Environmental Health Consultation Response	Officer	Alan Taylor
---	----------------	--------------------

Detail: Planning request 3/2017/1110

Address:	Neville street Longridge PR3 3FD			 <p>Ribble Valley Borough Council www.ribblevalley.gov.uk</p>
Application Ref:	37990	Case Officer:	Robert Major	
Response Ref:	/ENV/01	Issue Date:	11 December 2017

PROPOSED PLAN

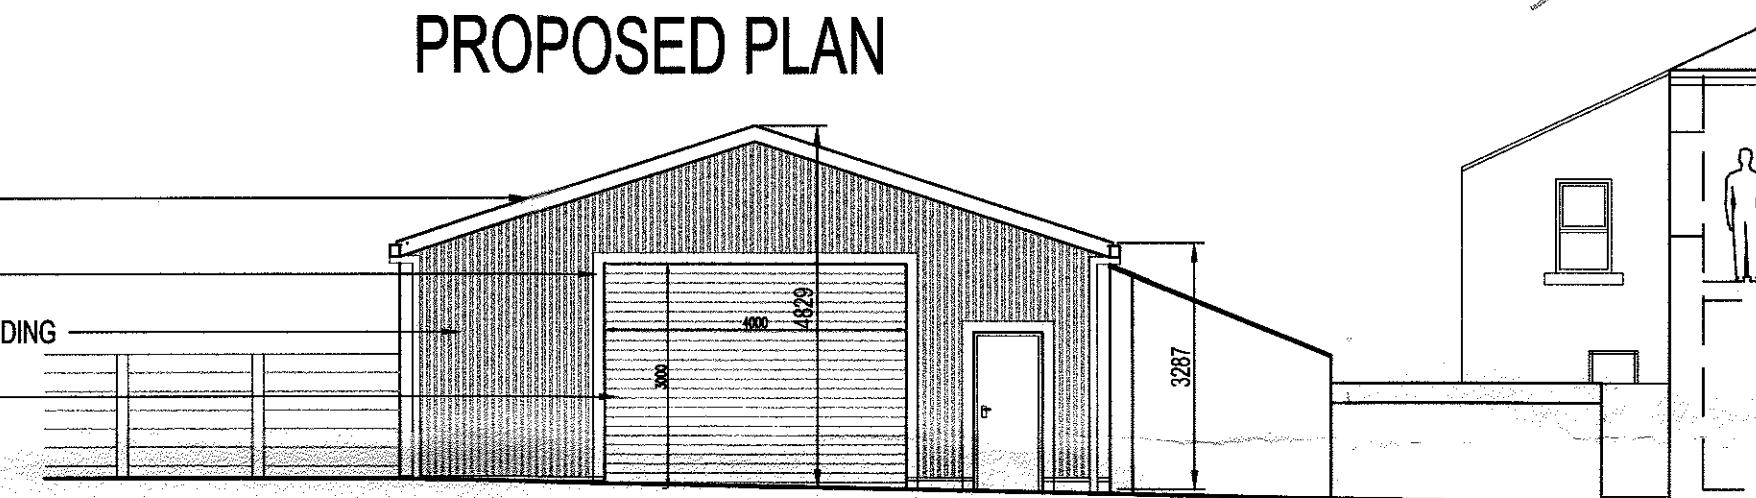
General Comments/Observations	
1.1	The planning request is for comments for the demolition and rebuild of an existing single storey workshop and store with an extended perimeter line.
Suggestions/Mitigation	
2.1	The perimeter of the new build construction take's the perimeter up against the neighbouring property which is a car dealership.
Conclusions/Suggested Conditions	
2.2	The above observations have been provided on the basis of the level of information submitted and the comments contained within this response represent officer opinion only, at the time of writing, without prejudice.
2.3	Should you be minded to approve the application, notwithstanding other considerations, I would suggest that the following conditions be attached should you feel they are relevant and justified:
2.4	No comments
	Officer:
	Alan Taylor
